City of Albuquerque Stormwater Construction Site Inspection Report

General Information					
ESC File No.	K08E003		Project Name:	Paradise RV Park Phase 2	
NPDES Id. No.	NMR1006HM		Location:	Volcano Rd. and 102nd Street	
10/17/2025	Owner		Contractor		
Operator	West Mesa RV Park, LLC				
Contact name & title	Karan Rai				
e-mail	karanveer.ra@gmail.com				
Contact Phone #	760-783-6599				
COA Inspector	James Hughes		Start/End Time:	10am	
Construction Phase:	Phase 2 was graded without approval				
Type of Inspection:	Regular	Storm Event	Post Storm Event >0.25"	311/Complaint	Follow Up
Weather at time of inspection?		Clear		Temperature: ~ 50	
Estimated date of last storm 0.25" or greater		10/14/2025

TEMPORARY EROSION AND SEDIMENT CONTROL PLAN

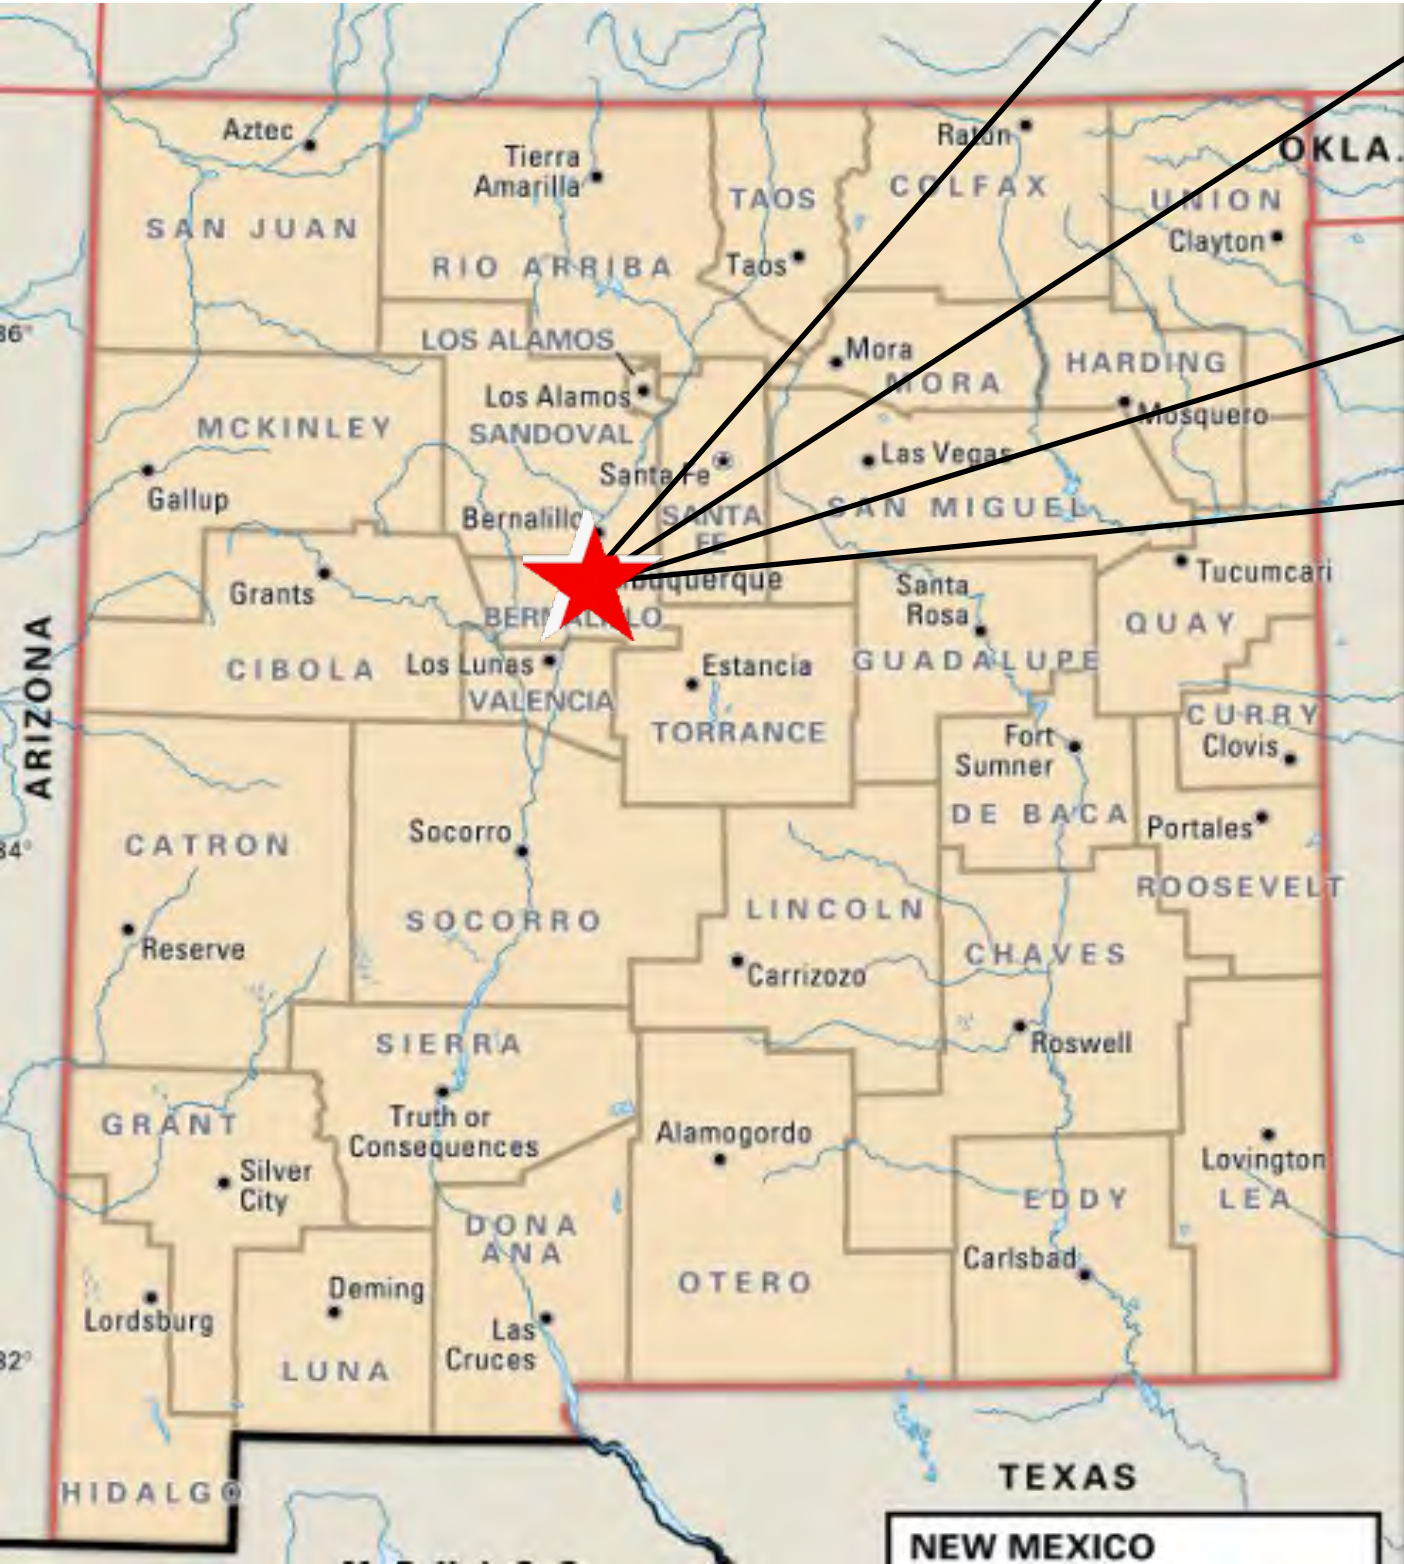
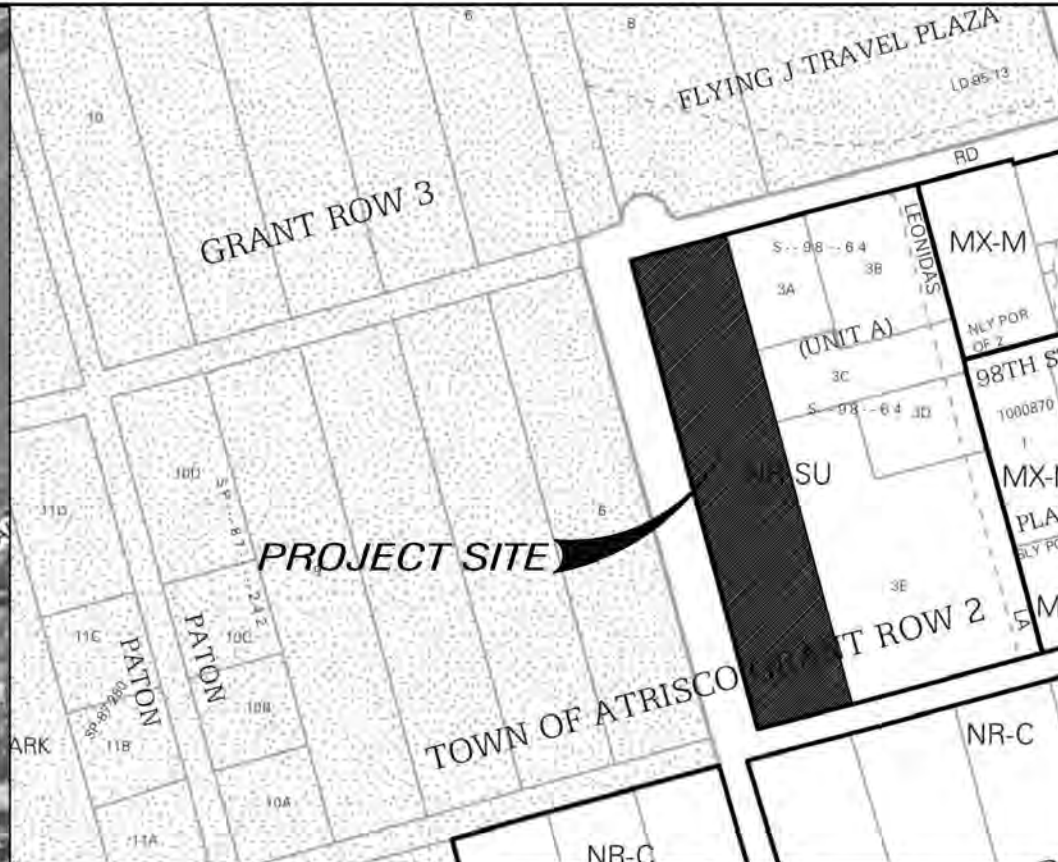
Item Number	Deficiency/ Corrective Action				
1	<b>NOI</b> - Phase 2 construction began one year ago without submitting the property owner's Notice of Intent and ESC Plan to the City for approval. The NOIs and ESC Plans submitted on 8/27/25and 10/7/25 contained deficiencies that were sent to you on 9/3/25 and 10/17/25, which must be addressed before approval. <b>Required Mitigation:</b> The property owner’s NOI is acceptable, but the off-site construction support activities and upstream BMPs are still not shown on the ESC Plan. The ESC Plan must be submitted to the City of Albuquerque for review and approval in accordance with Albuquerque’s Erosion and Sediment Control (ESC) ordinance § 14-5-2-11(A).				
2	<b>BMPs</b> - The Phase 1 pond should still function as one of the BMPs protecting Volcano Rd from stormwater crossing 102nd St. adjacent to this site, but it was filled a year ago during the unauthorized start of Phase 2 earthwork. The Phase 2 block wall along 102nd St., built over two years ago, further contributed to erosion on Volcano Rd and City Pond NE2 south of your site, violating city Ordinance § 14-5-2-12(B)(3). During storms a month ago, large amounts of sediment-laden stormwater entered 102nd St. at Avalon Rd., though no such deposits were seen in the 0.35' storm three days ago. Significant sediment was also present in Volcano at 102nd St., indicating a second runoff source that adds to erosion and sediment in the city pond. <b>Required mitigation</b> includes diverting upstream off-site stormwater around disturbed areas with temporary compacted berms, swales, or storage in temporary sediment basins. The CGP requires a design for 2-year storms according to CGP 2.2.12, and City Ordinance § 14-5-2-12(B)(3) mandates a 10-year storm design from May 1 through October 31. The design must include retention of the upstream offsite stormwater and prevent flows from reaching the area of erosion in Volcano Rd and the City's pond. Provide design calculations and construction specifications on the ESC Plan stamped by a registered PE to the city for approval and construct the BMPs immediately.

3	<b>Sediment</b> - This site has disrupted the drainage pattern into the City's pond south of this site, resulting in significant erosion and sediment damage in the city's Municipal Separate Storm Sewer System (MS4). Neither Phase 1 nor Phase 2 construction provided a non-erosive outfall in violation of CGP 2.2.11. and the premature diversion of off-site flows without BMPs seem to be the primary cause of the damage. City personnel and equipment from the Street Maintenance Division of DMD were repairing the erosion on the south side of Volcano Rd. Friday morning. The crew said they plan to repair the city’s pond maintenance road and remove the sediment from the bottom of the pond. <b>Required Mediation:</b> Since city crews are repairing the E&S damage, no further mitigation is required. You must prevent further erosion in Volcano Rd. and the City's Pond.
